Ribble Valley Borough Council
Housing & Development Control

Application no: **3/2021/0344**

Address: **Automotive Tools Hambledon View Read BB12 7PD**

Proposal: **Proposed extension to create vehicle storage at ground floor level and office accommodation/storage at first floor level. Resubmission of approved application 3/2020/1043.**

PROPOSED SITE PLAN	
Site: Automotive Tools Hambleton View Read BB12 7PD	Client: Mr Peter Maddock
Date: 28.11.20	Scale: 1:200 @ A2
Project No: AUT/01 Dwg 04	Drawn: DS
Amendments:

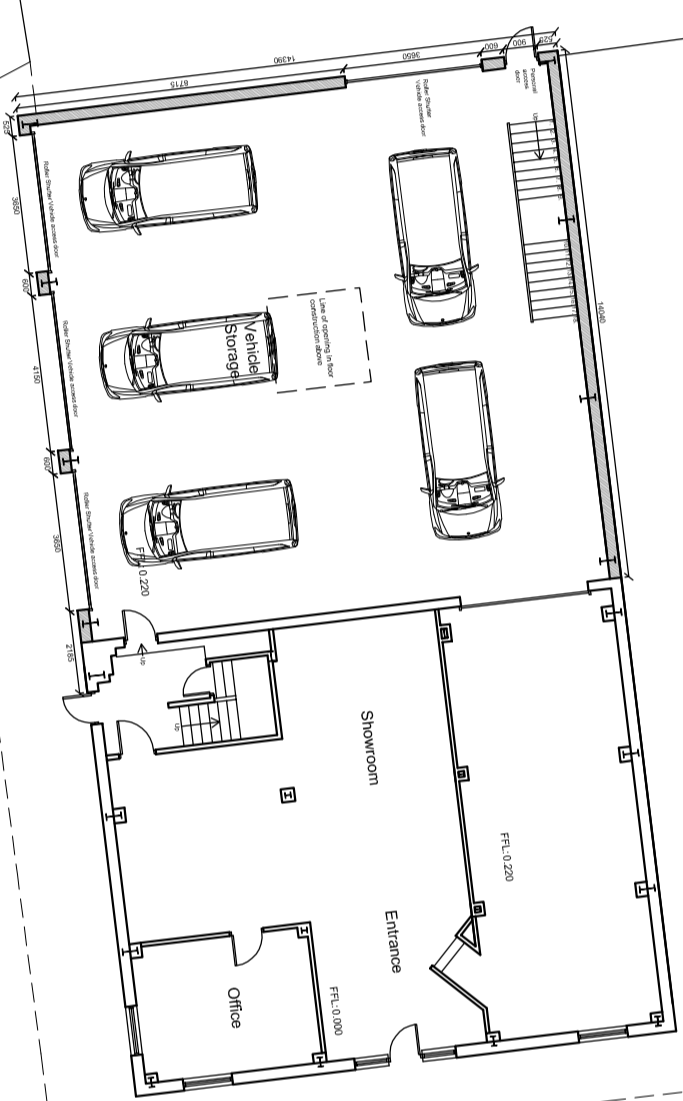
Alike the previous highway comments dated 18th December 2020 for application reference 3/2020/1043, the proposed alterations and extension will involve alterations being made to the profile of the existing adopted footway levels fronting the application site and therefore, subject to the applicant entering a Section 278 agreement with

Lancashire County Council under Section 278 of the Highways Act 1980, the proposal would not raise any highway concerns.

1. No building or use hereby permitted shall be occupied or use commenced until the profile/levels of the existing footway has been altered to suit the proposal and a suitable vehicular dropped crossing has been constructed across the footway fronting the application site in accordance with Lancashire County Council Specification for Construction of Estate Roads, to be retained in that form thereafter for the lifetime of the development.

2. Before the building hereby permitted is brought into use, the garage doors shall be of roller shutter type as shown on the submitted plans and be permanently retained in that form thereafter for the lifetime of the development.
